Addendum No. 1

RE: Contract ID: C201464
WBS # 112.1044027
F. A. # ER-NC05 (2)
Haywood County
Slide Repair on I-40 Between
Mile Marker 1 and Mile Marker 5

June 21, 2005 Letting

PROJECT REFERENCE NO. 1121044027	SHEET NO. EC-4/CONST.5
RW SHEET NO.	
ROADWAY DESIGN ENGINEER	HYDRAULICS ENGINEER

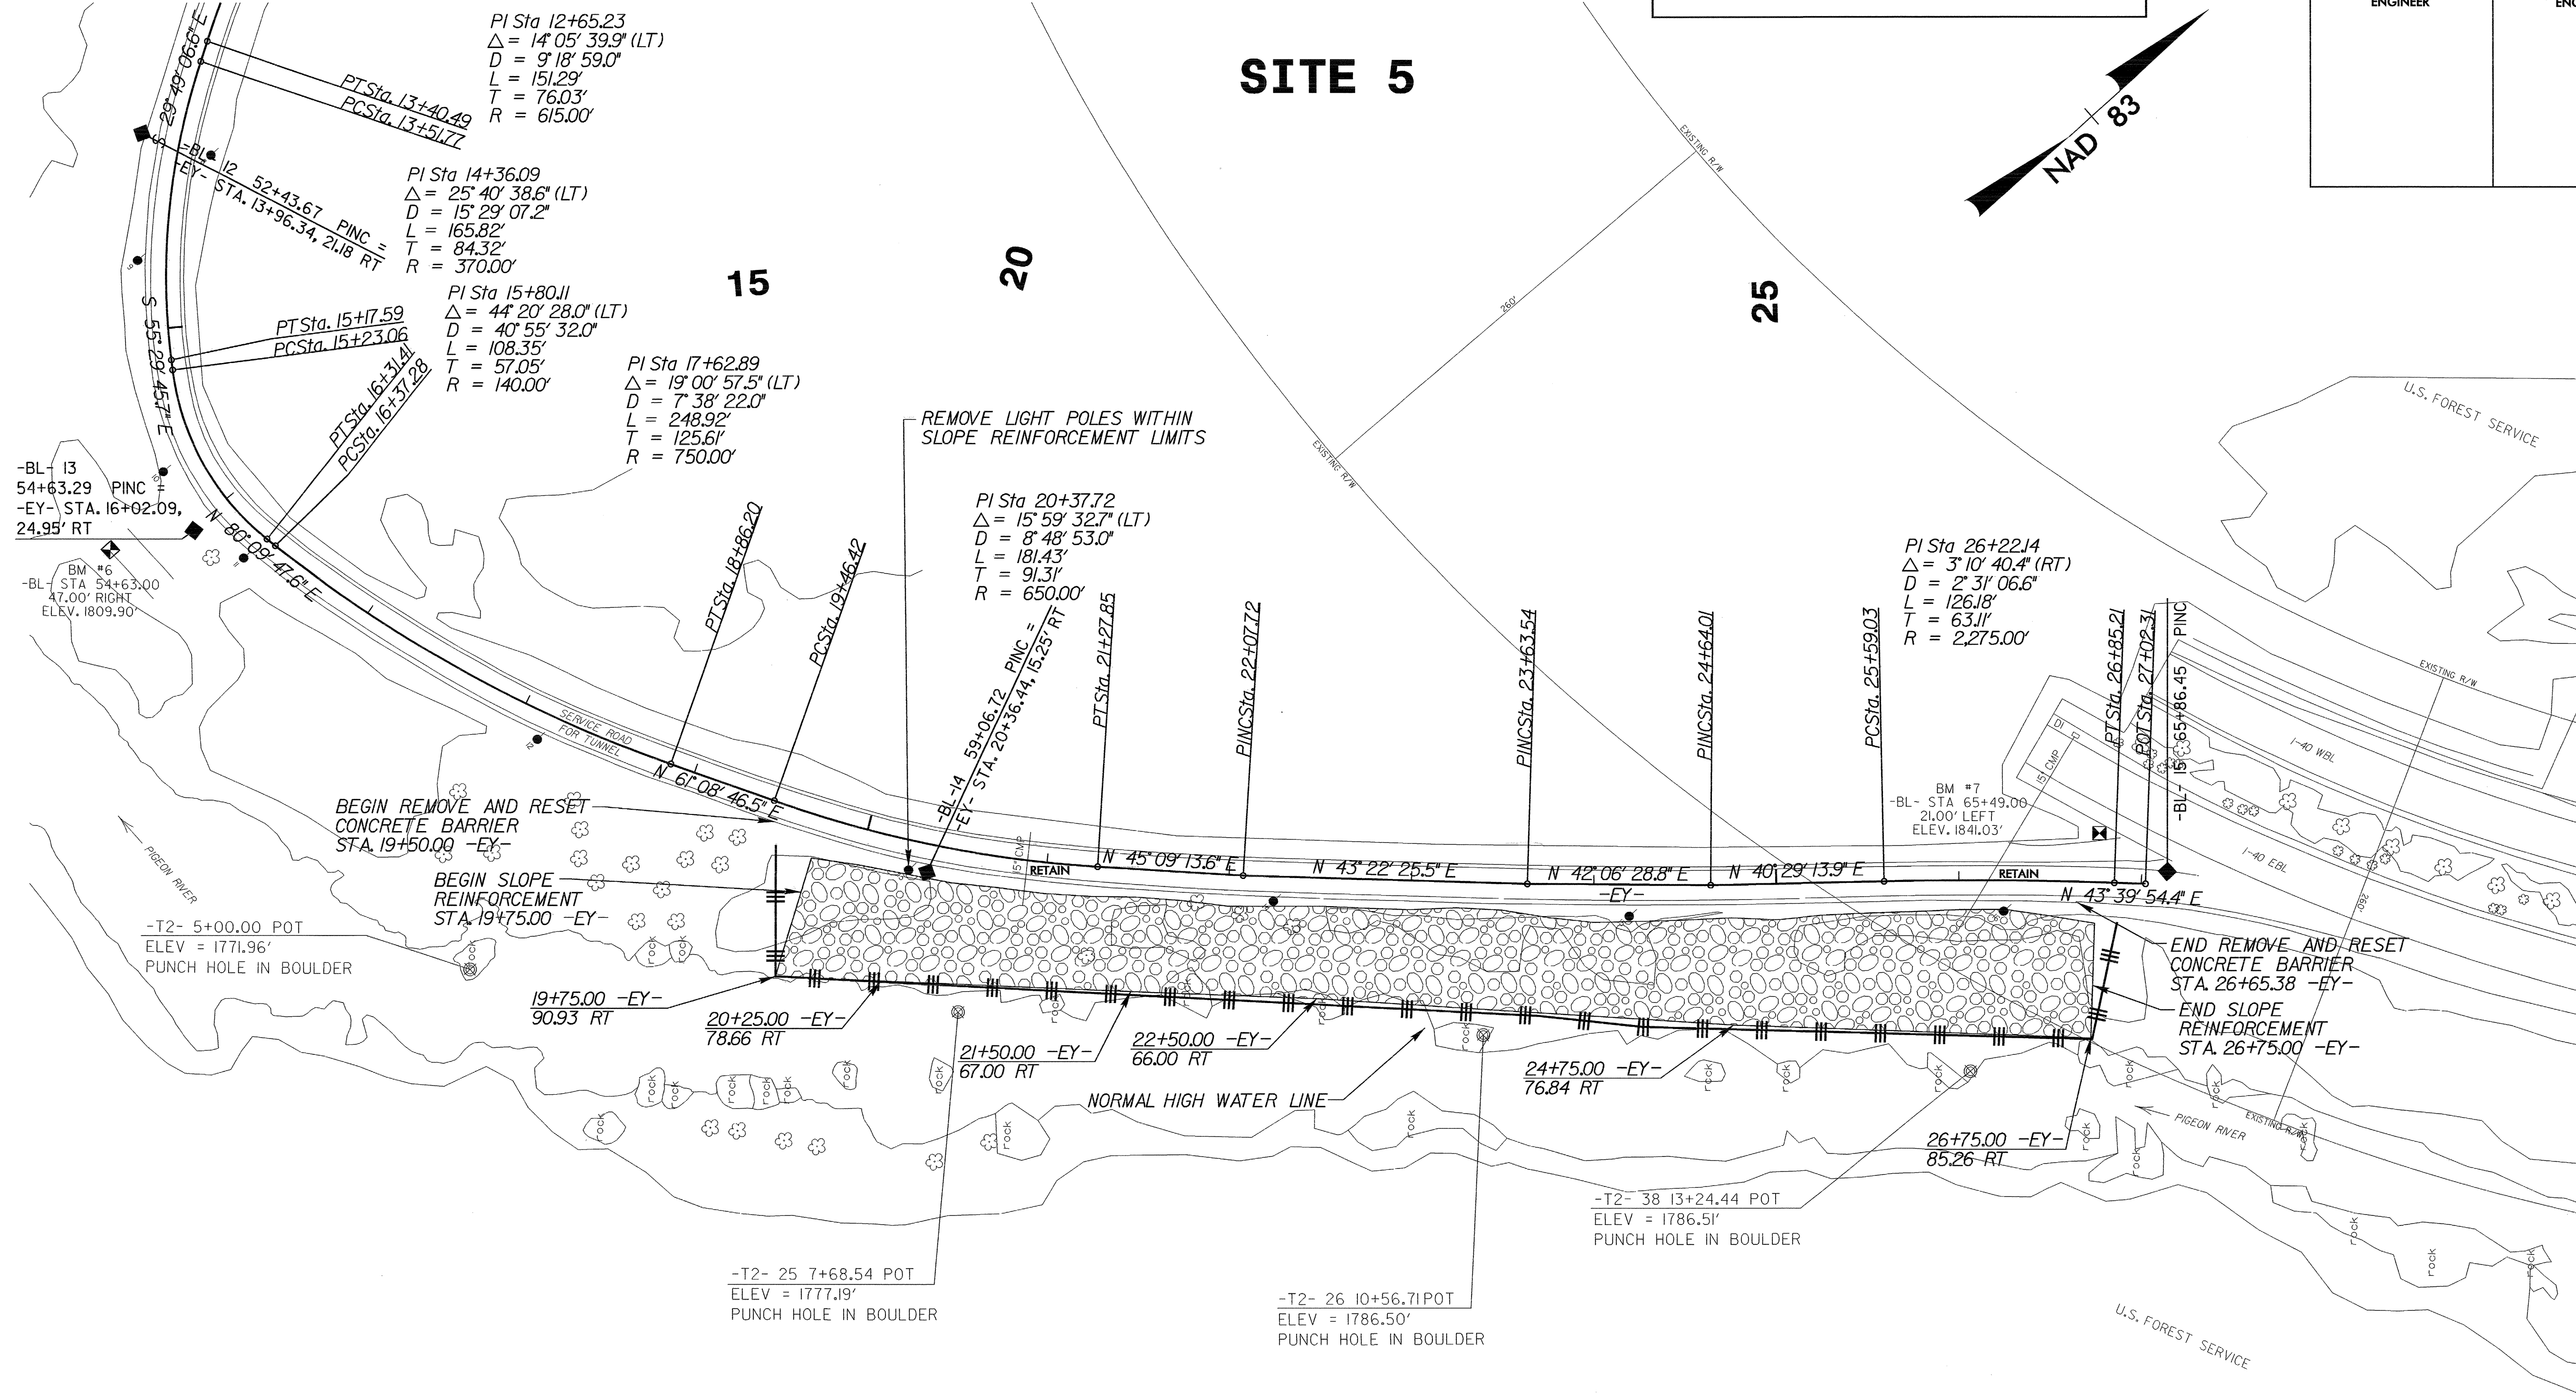
The Contractor's attention is directed to the fact that recent storms have created high water elevations in the Pigeon River. Existing site conditions have changed from those shown in the advertised plans. This resulted in the loss of additional materials at both slides # 4 and # 5.

The amount of material lost is not significant enough to require a plan revision. The Contractor is advised to examine the site in accordance with Section 102-6 and shall include all cost for the work required of Section 226 in his Lump Sum bid for "Grading." No adjustment will be made to the Lump Sum price bid for "Grading" due to these changed site conditions.

PROJECT REFERENCE NO.	SHEET NO.
112.1044027	EC-3/CONST.4
RW SHEET NO.	
ROADWAY DESIGN ENGINEER	HYDRAULICS ENGINEER

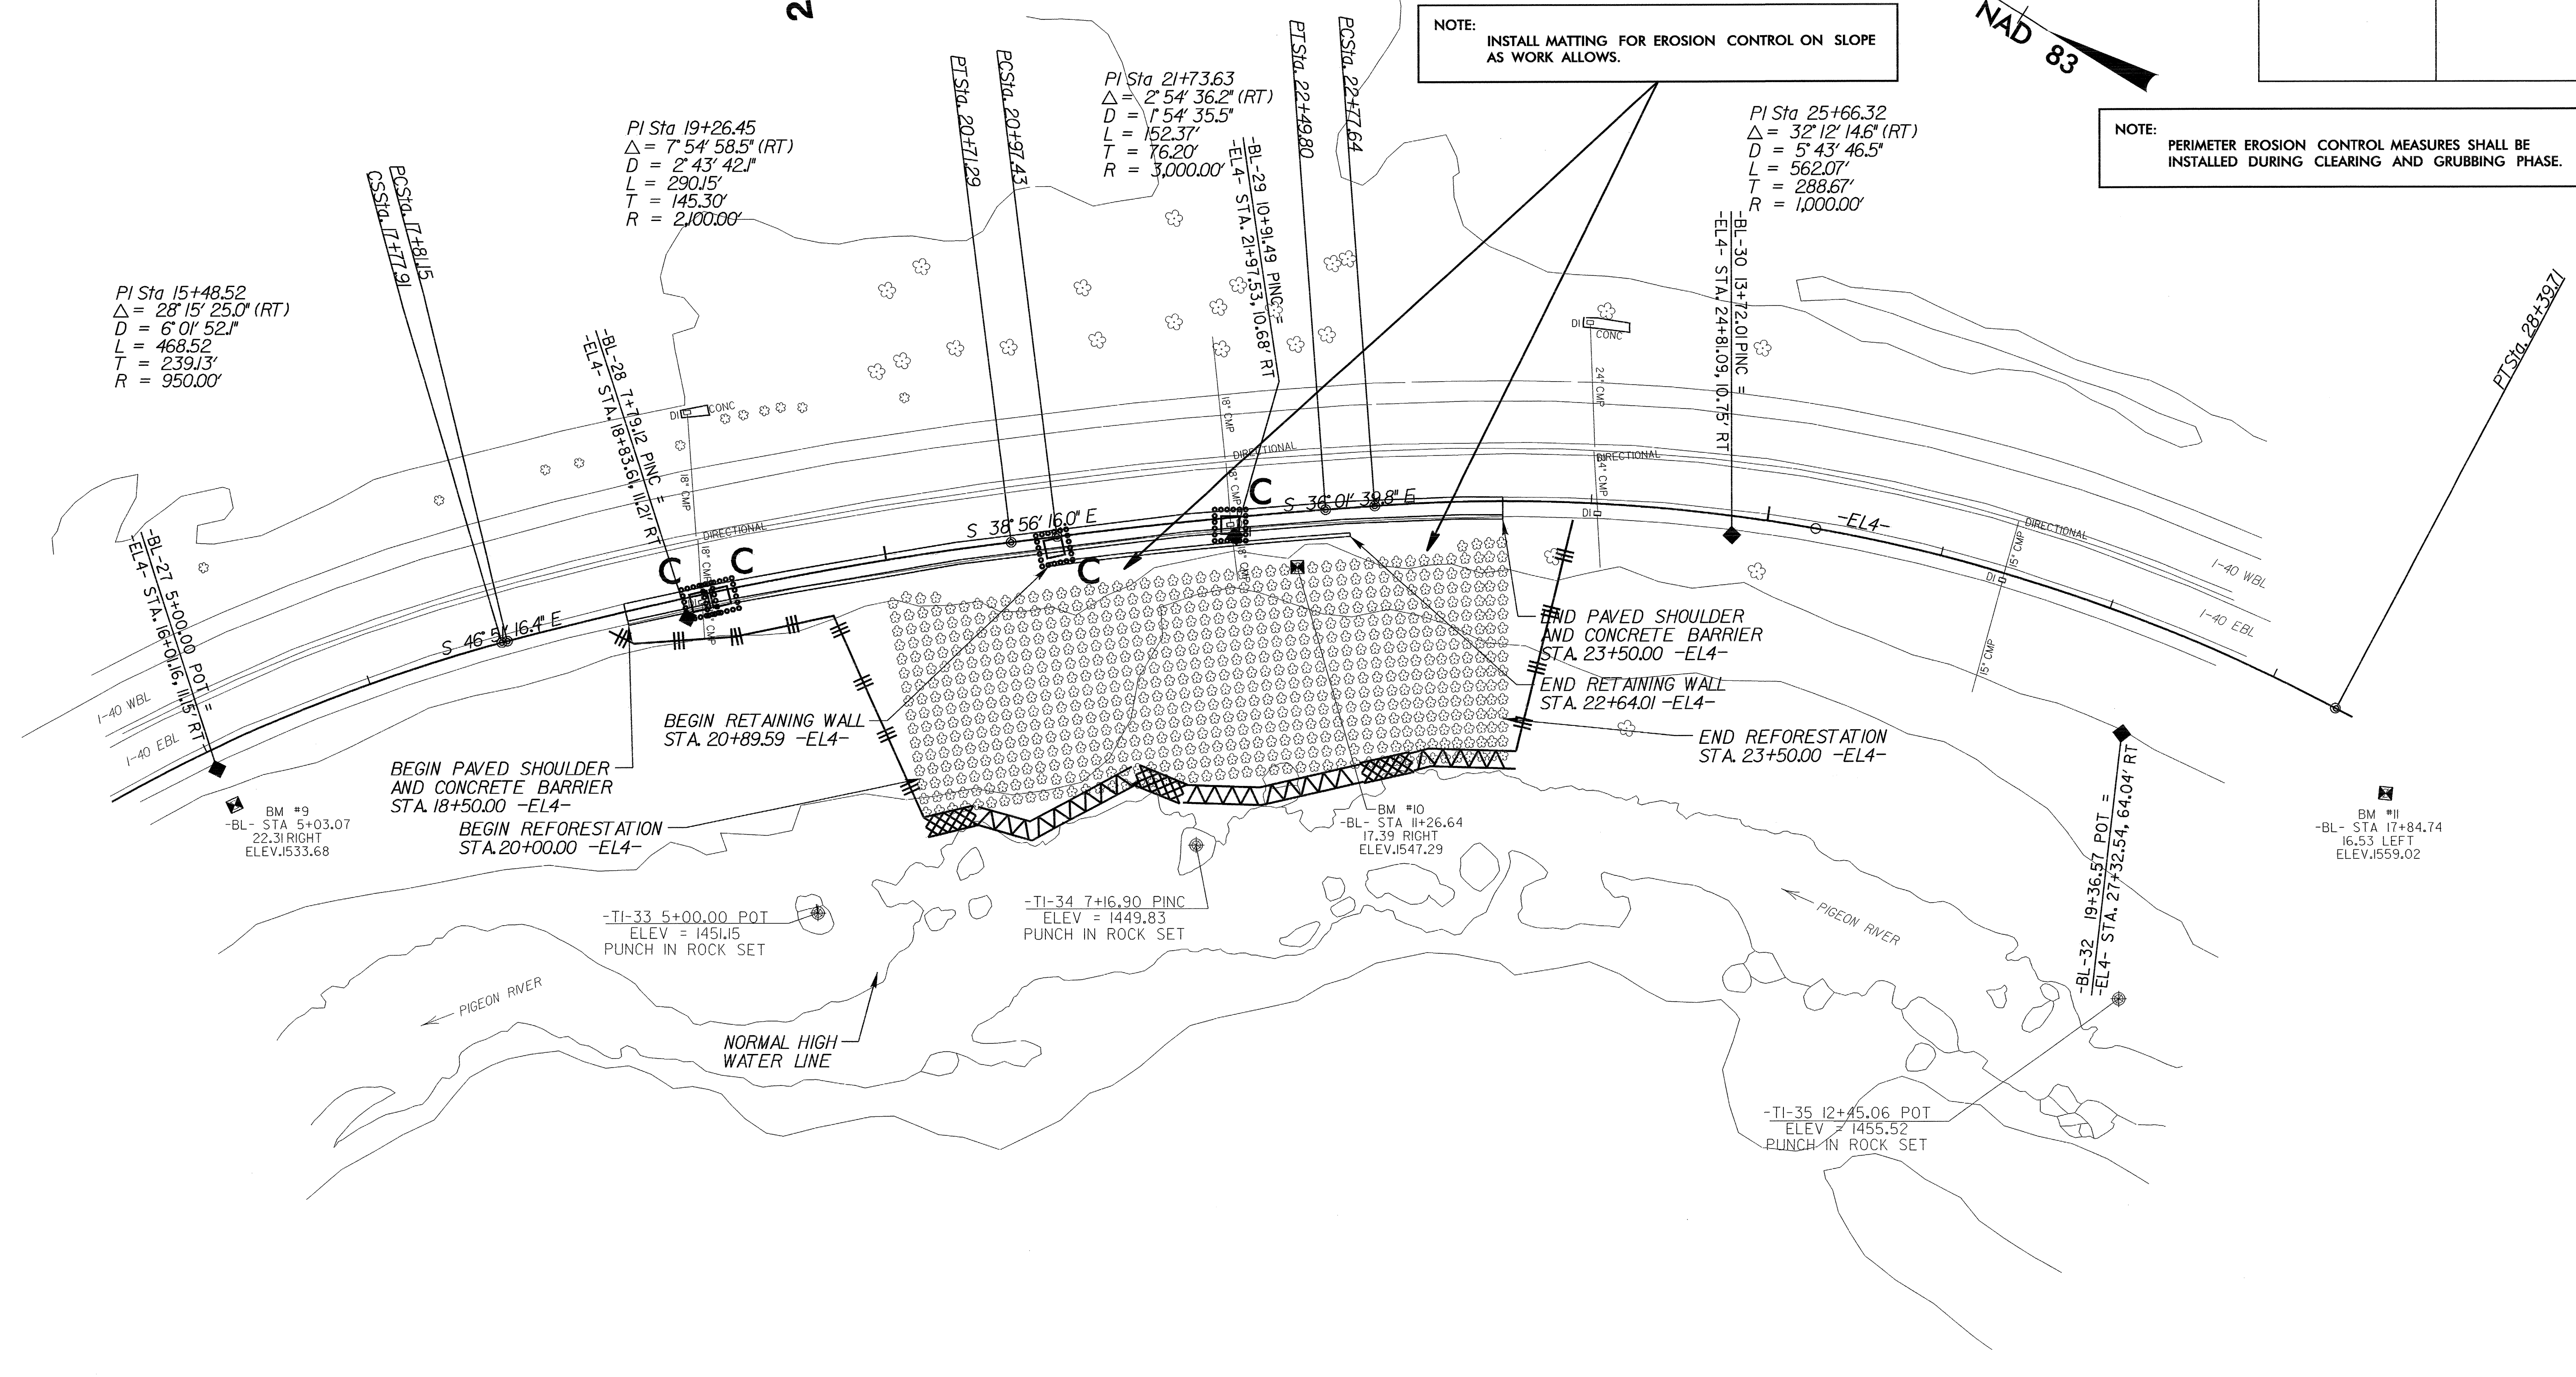
Due to the more restricted work area at slide # 4, the Contractor will be allowed to move the Portable Concrete Barrier (PCB) to within 4' of the center of the eastbound lane as needed. The provisions of ICT # 1 are still applicable.

Item # 41, Reset Portable Concrete Barrier, will only be measured and paid for the initial placement of the barrier at 2' from the outside edgeline and for it's final location as stated in Step 2 and 4 on Page 52 of the proposal. Any additional movement of the PCB to within 4' of the center of the lane due to the Contractor's method of construction will be considered incidental to the various items in the contract and will not be measured or paid for separately.
